PLANNING BOARD REPORT PORTLAND, MAINE

4-unit Condominium Development
31 Fore Street

Level III Site Plan and Subdivision Review
Peninsula Property Development, Applicant

Submitted to: Portland Planning Board Date: March 18, 2016 Public Hearing Date: March 22, 2016	Prepared by: Jean Fraser, Planner CBL: 016 J026001 Project #: 2016-005
--	--

BACKWATER VALVE ASSEMBLY

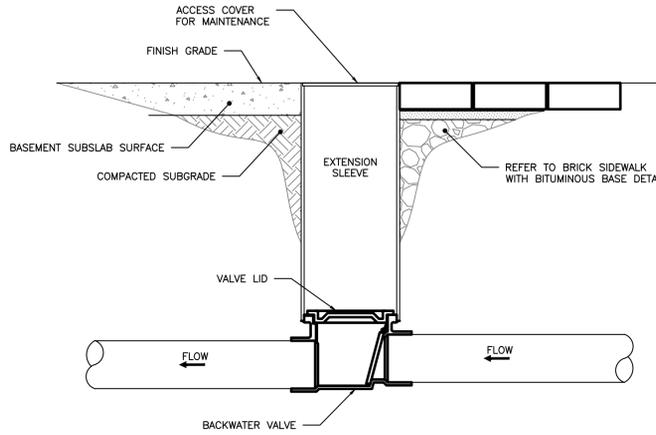
The applicant has submitted a Final Stormwater Report and an Erosion Control Report in Attachments I and J. The proposals for the stormwater raingarden have been revised to address the Peer Engineer's earlier comments and the only issue is the location of the sewer back water valve which is proposed in the ROW (Attachment 3). A potential condition of approval addresses this minor concern.

- v. That in respect of the City's ROW the applicant shall:
 - a. address the comments of the Department of Public Work David Margolis -Pineo dated 3.16.2016 and the comments of the Peer Engineer Dave Senus dated 3.17.2016;
